Ribble Valley Borough Council
Housing & Development Control

Application no: **3/2019/0554**

Address: **Three Millstones Inn Waddington Road West Bradford BB7 4SX**

Proposal: **Proposed new single storey building at the rear of the public house to create an additional guest bedroom**

**A200**

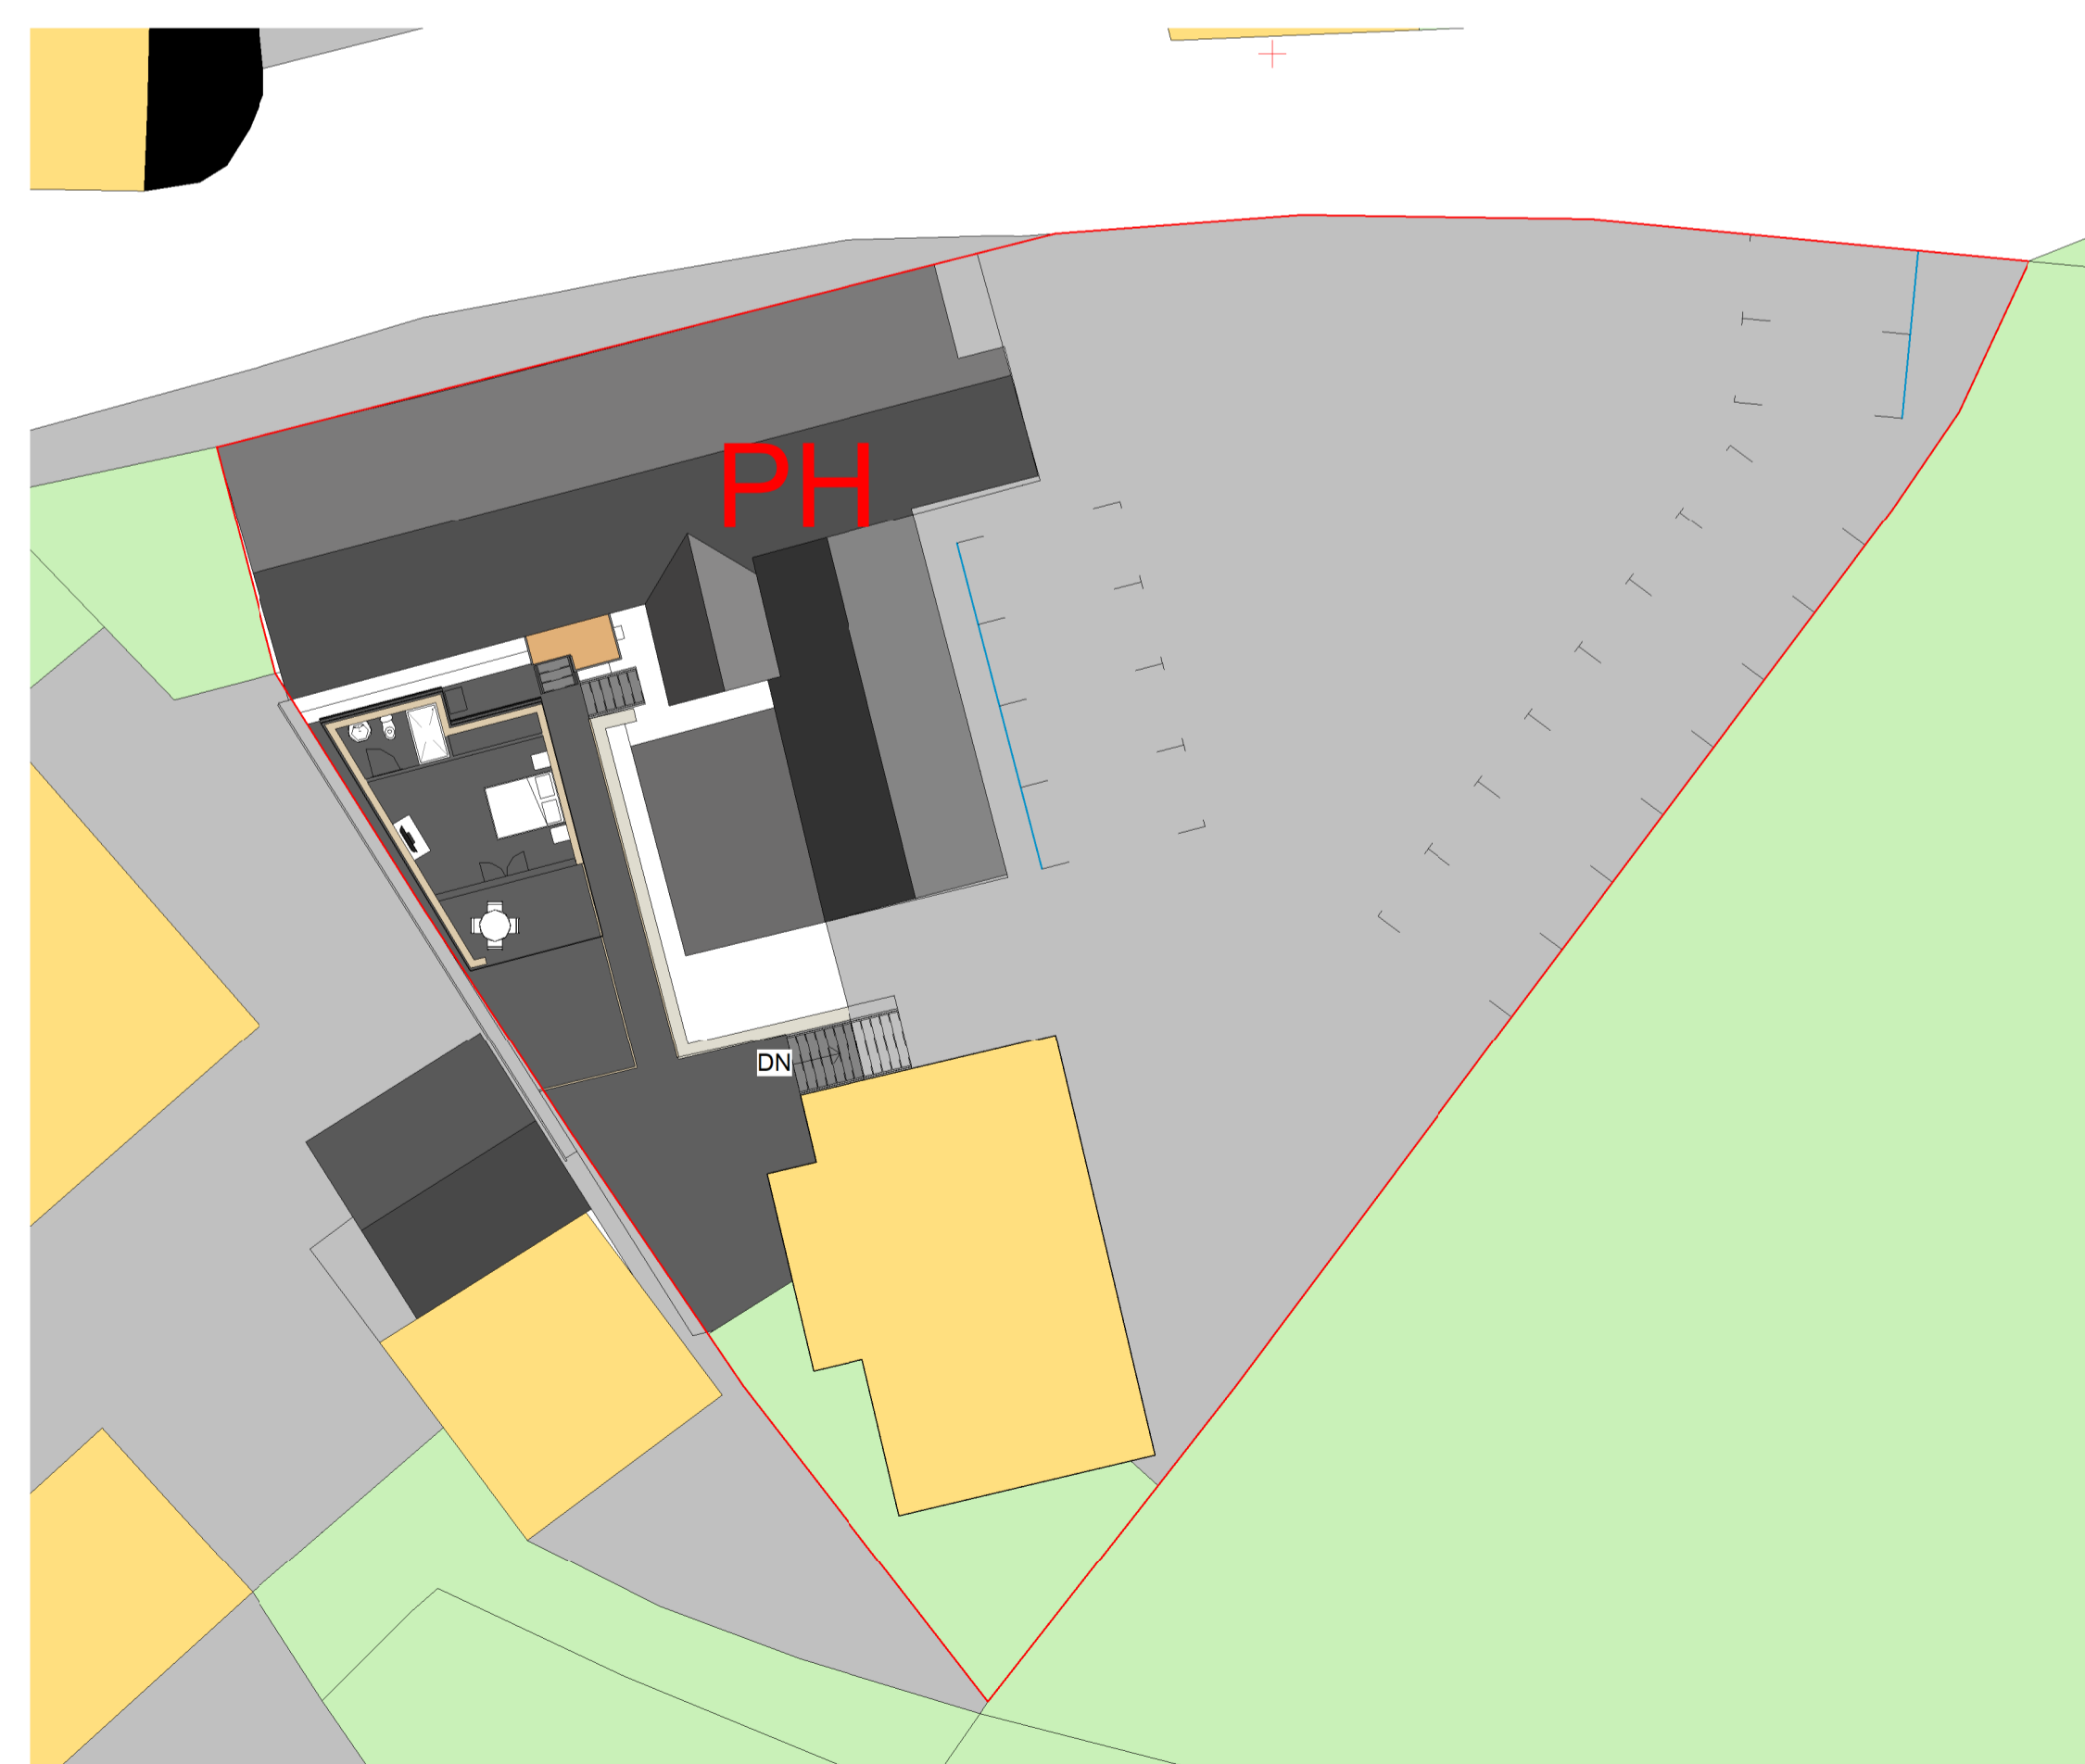
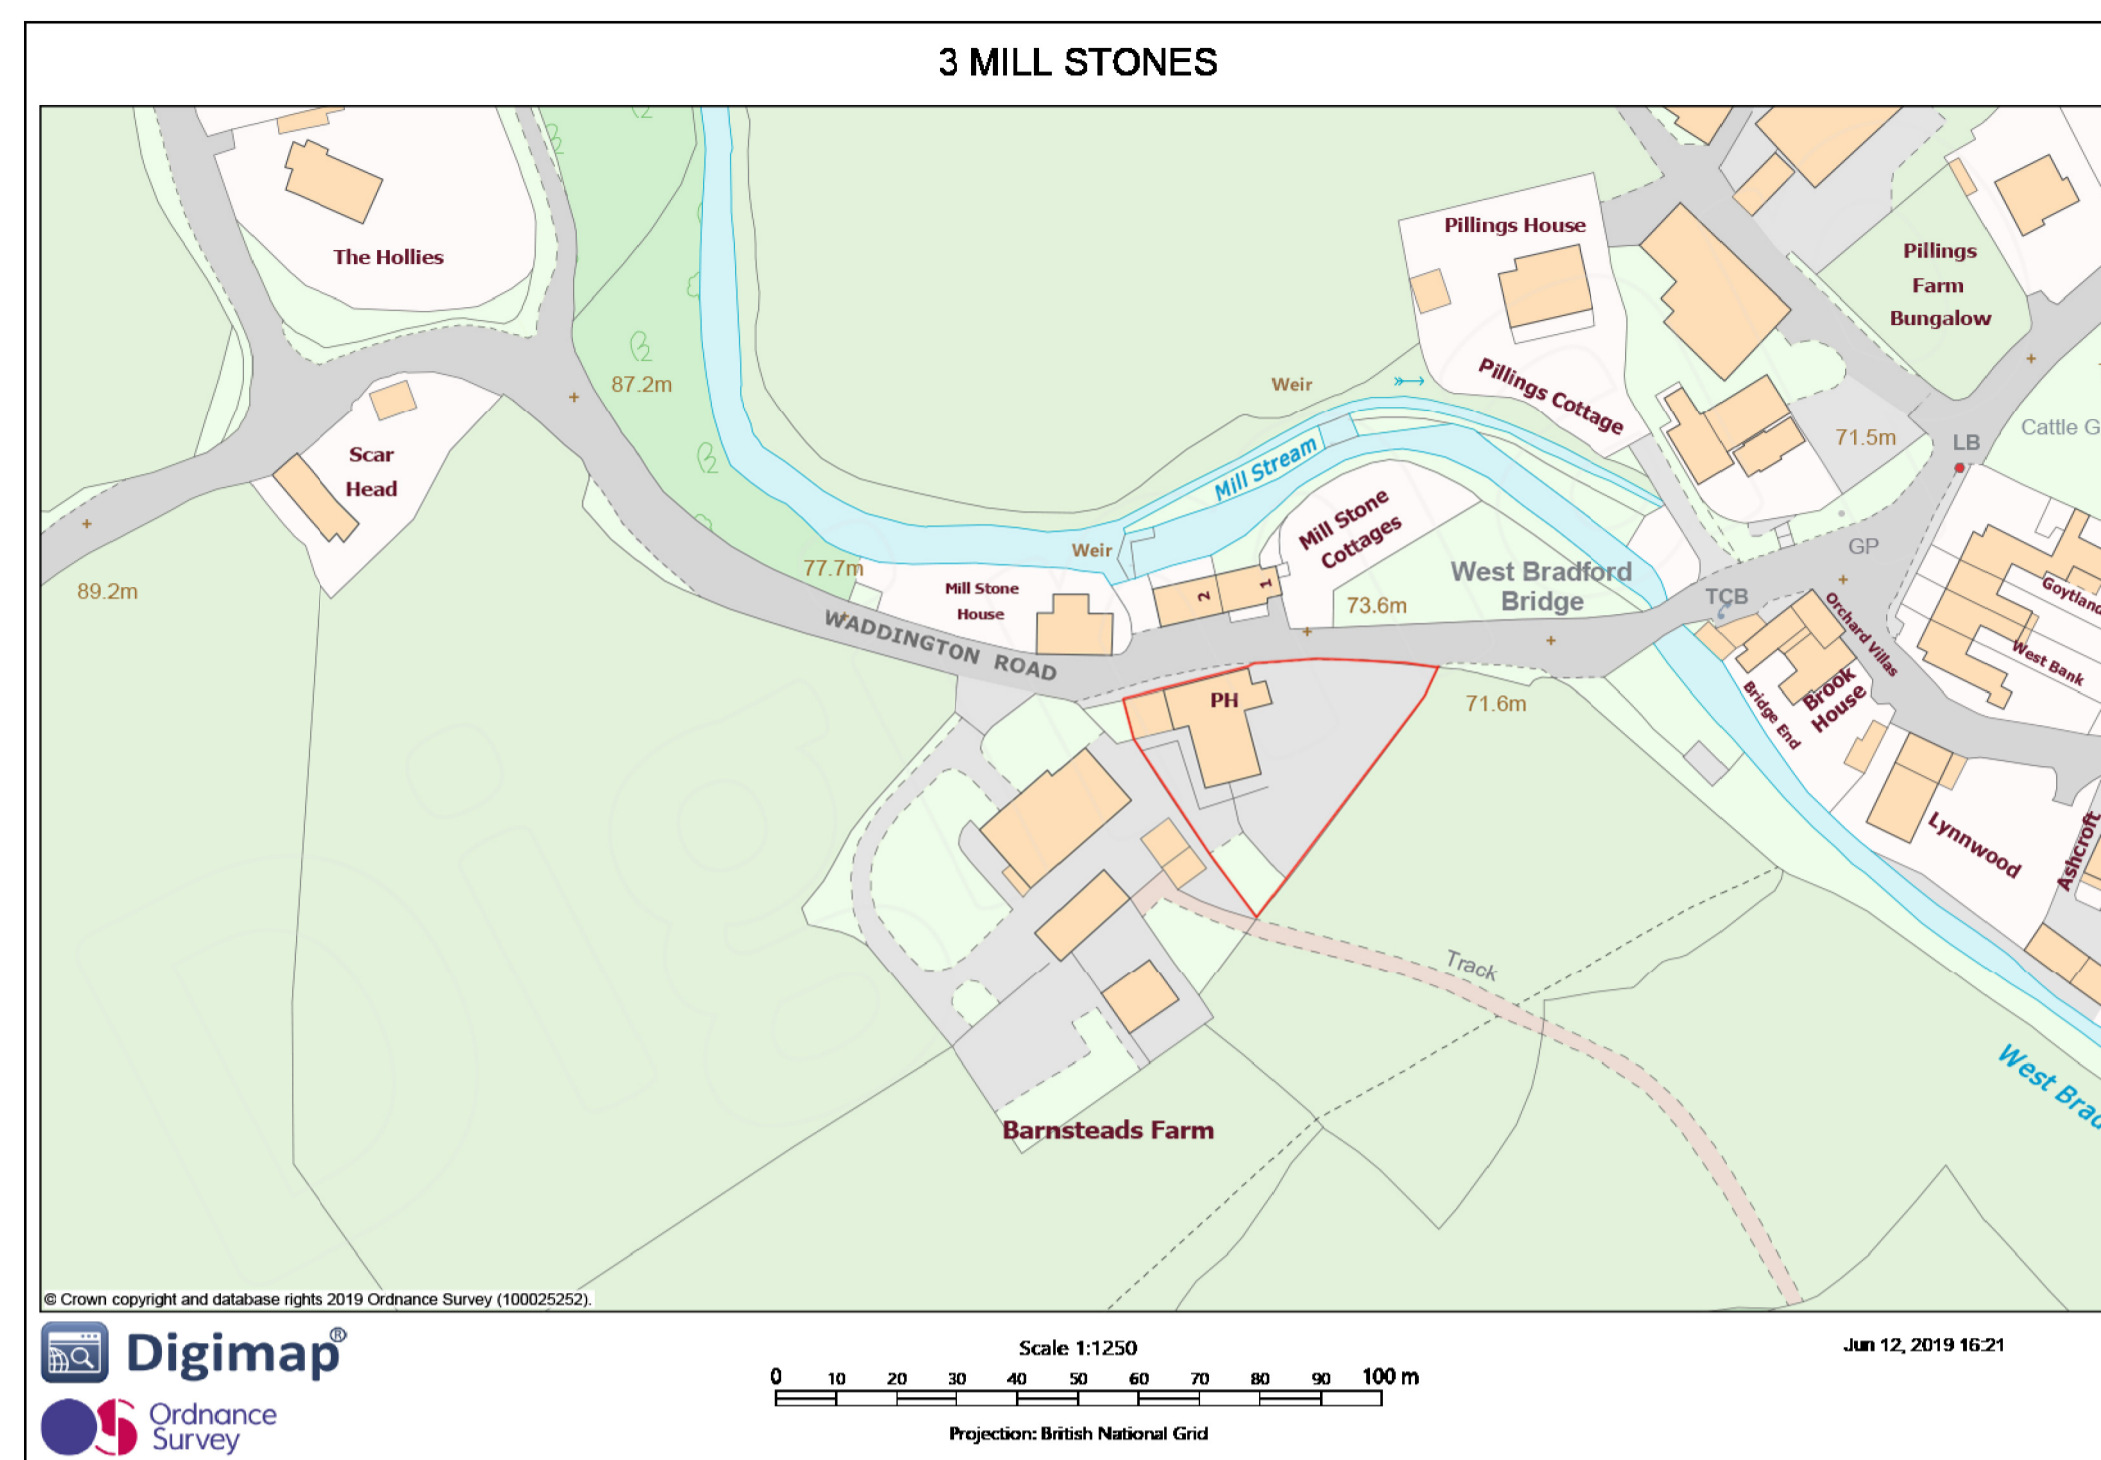
As a result of the planning application, a further 1 parking space will be required to be provided within the curtilage of the application site, to which simply cannot be accommodated for.

In accordance with the submitted site plan, A200. Project number PHA/328. The plans demonstrate 13 parking spaces as opposed to the 17 parking spaces as stated within the submitted application form.
